**Consultation Response from KC,
Ecology Unit****2026/91564 land off, Heaton Grange, Hanging Heaton, Batley, WF17 6EN****Erection of 21 dwellings****Date Responded: 23/07/2026****Responding Officer: Z. Hanshaw****Responding Ref: 2607/28**

I have reviewed the documents submitted as part of this application. I have no ecological concerns with this development but note that further information with regards to Biodiversity Net Gain will need to be provided.

Appendix V. ANNOTATED MAP OF THE SURVEY AREA POST DEVELOPMENT.

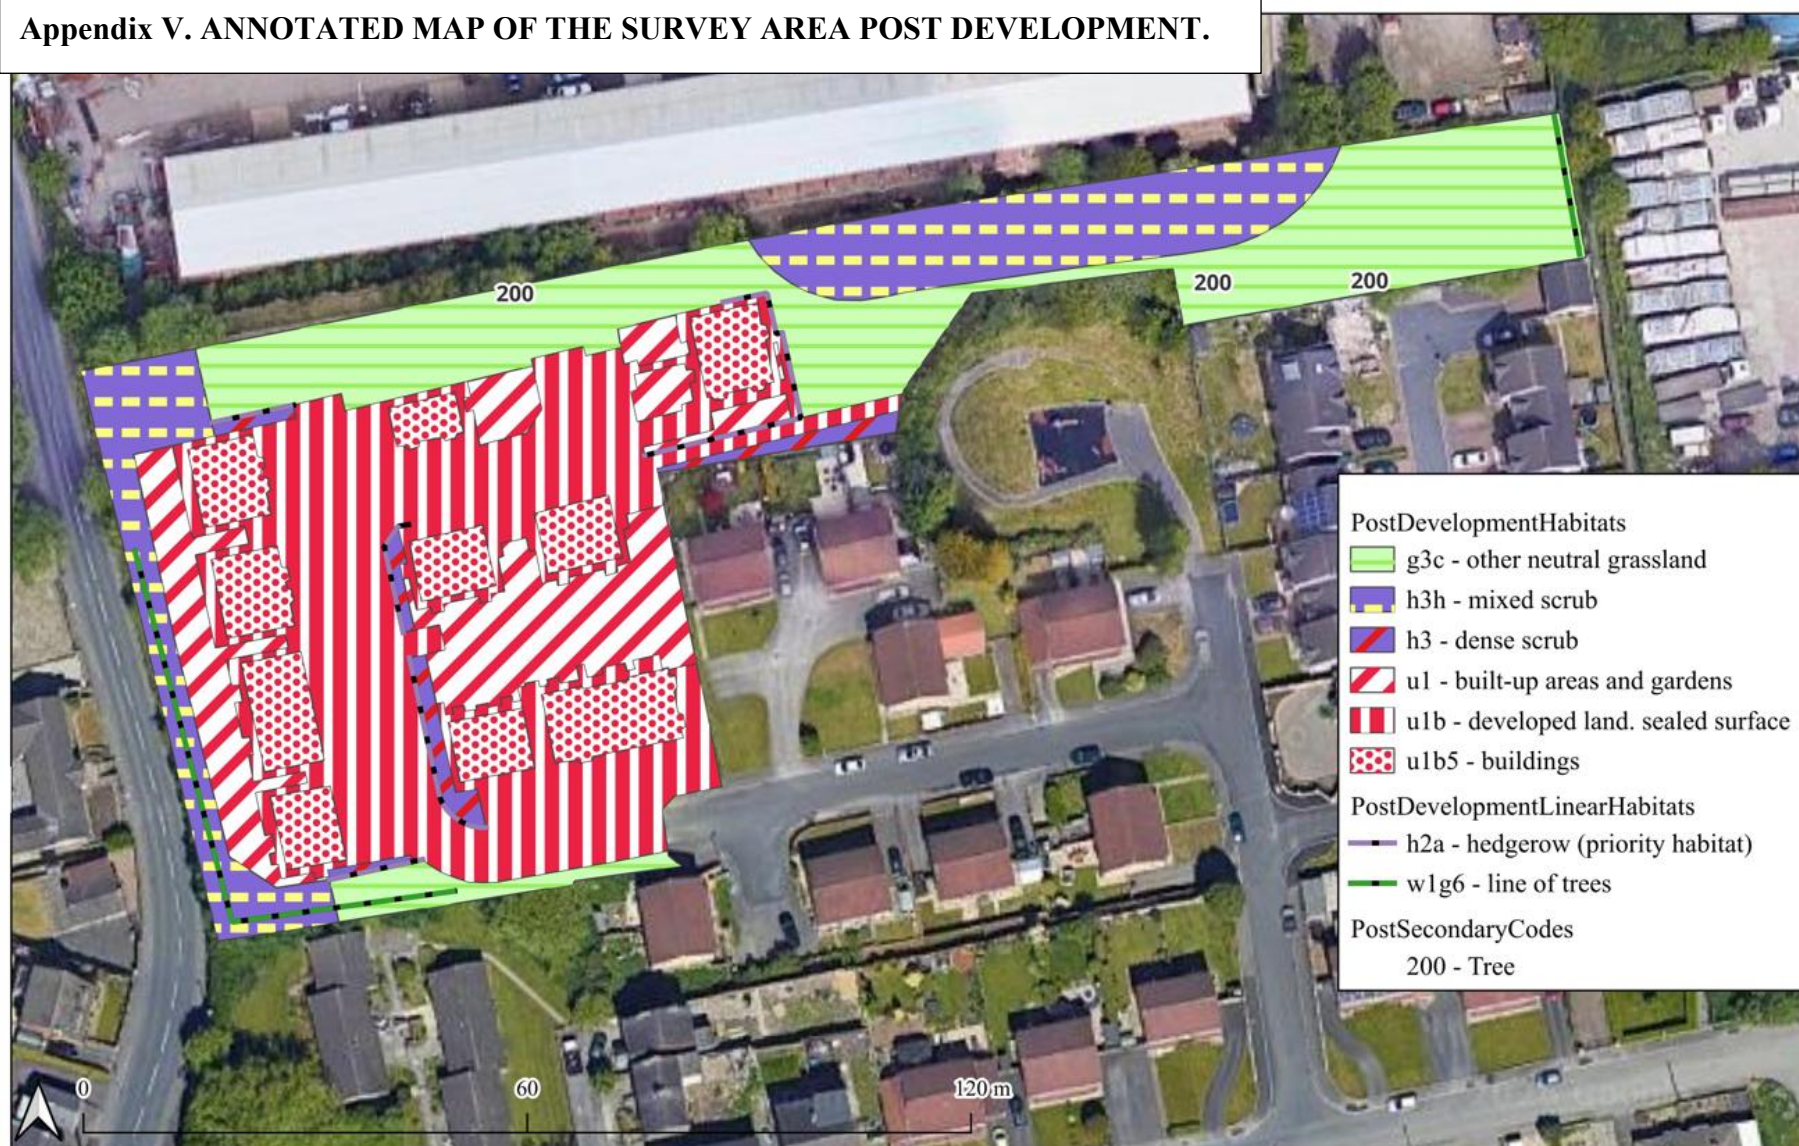
The Post Development Habitat Map (page 34 of the Ecological Impact Assessment) shows that there will be Other Neutral Grassland to the east of the site, which is identified as a drainage attenuation area in the Site Layout Plan. The metric should be updated to include this area as an attenuation basin, if that is the proposal.

An area of Dense Scrub proposed at the side of the road, to the west of plot 5. I am not convinced how viable this area of scrub will be, nor if it is appropriate in this location.

The proposed Other Neutral Grassland (ONG) is set out to be in Moderate condition, but no information on how this will be achieved. It also appears to connect with an existing playground, and 50 individual trees are also proposed in this area. Details on the viability of moderate condition ONG, in this area, should be provided.

The Planting Plan shows non-native trees and non-native shrubs will be planted within the development site. I would recommend that this is updated to ensure that only native species are included within the Planting Plan. The Planting Plan also shows areas of non-native shrubbery where the Post Development Habitat Map shows dense scrub.

I would recommend that the above plans and documents should be updated, alongside the Biodiversity Net Gain Metric, to ensure consistency between the submitted documents.
